CITY OF ALBUQUERQUE

**Re: Leyba Body Shop, Lot 16A/Block 3, Mesa Verde Addition, 103 Tennessee NE
Grading and Drainage Plan
Engineer's Stamp dated 10-08-12 (K19/D146)**

GRADING PLAN

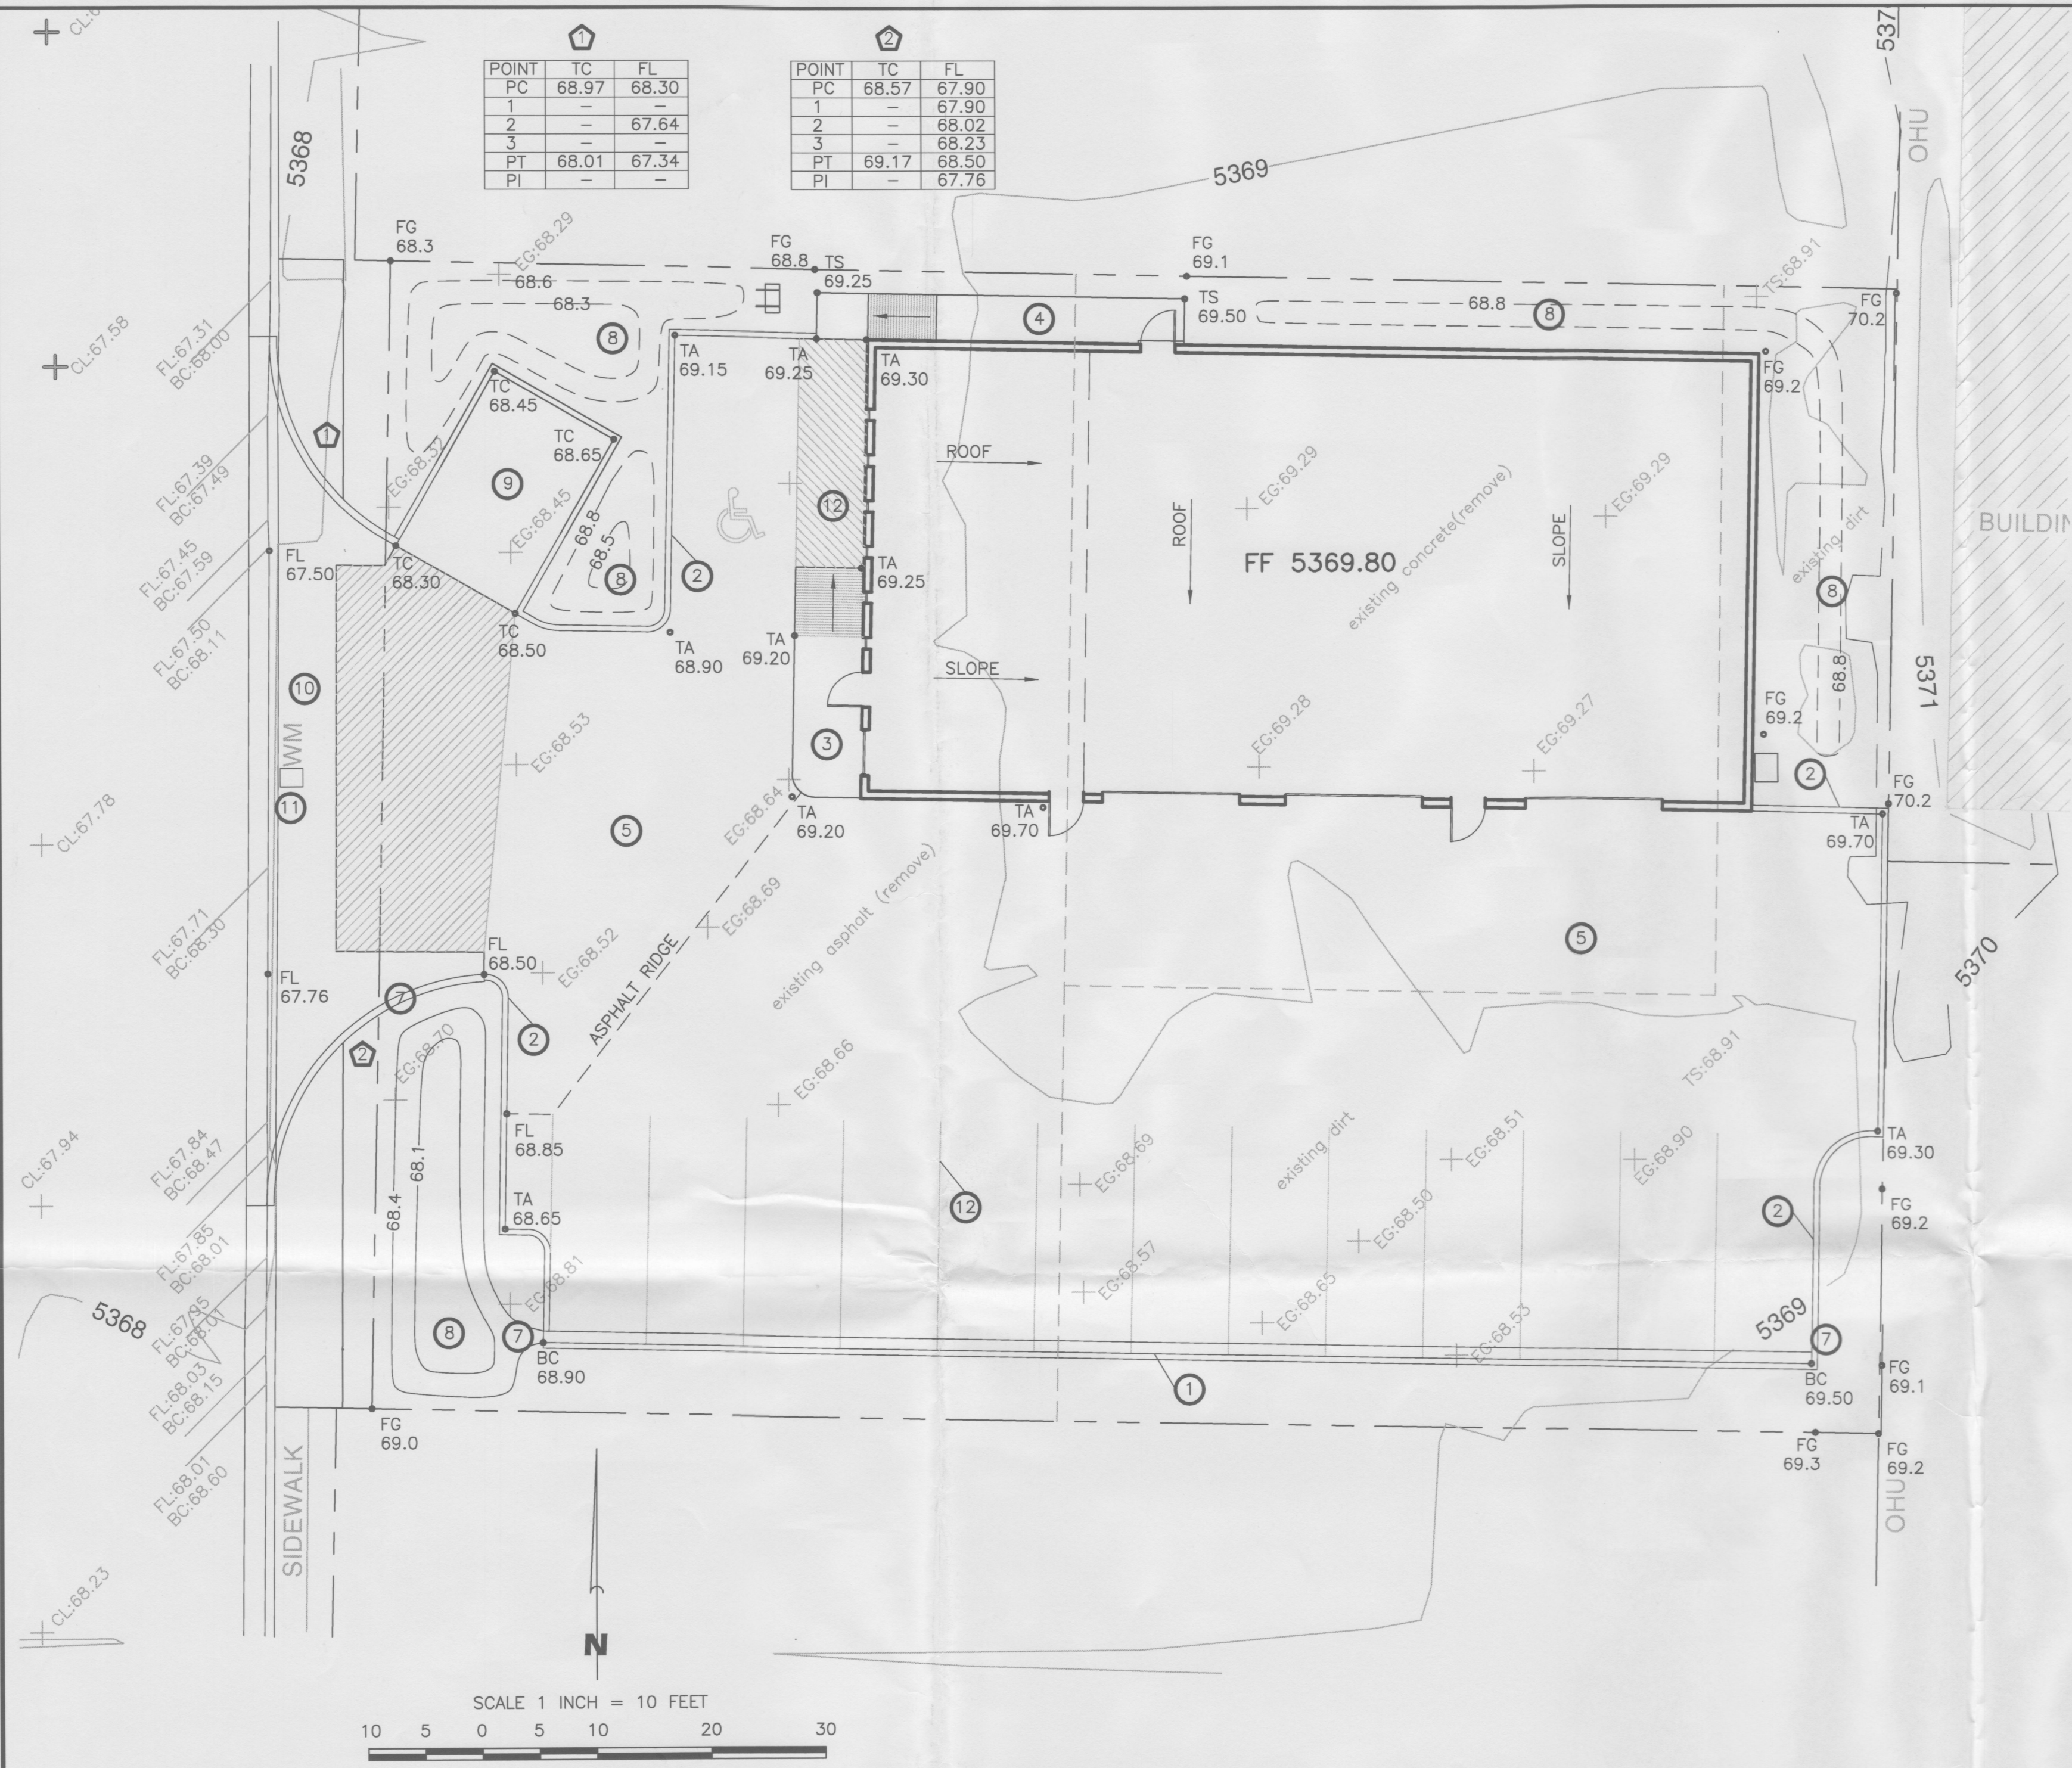
- Treatment "A" should not be used for calculating the exiting on-site and offsite runoff.
- The discharge from the site should match the exiting conditions.
- Provide ponding calculations for all the depressed landscaping areas to support the ponding requirements due to additional runoff under the proposed conditions.
- Due to its proximity to the building, we do not recommend depressing the landscaping area north of the building.
- Please avoid discharging over the sidewalk. Direct the runoff towards the right-of-way via the entrance or through the Sidewalk culverts.
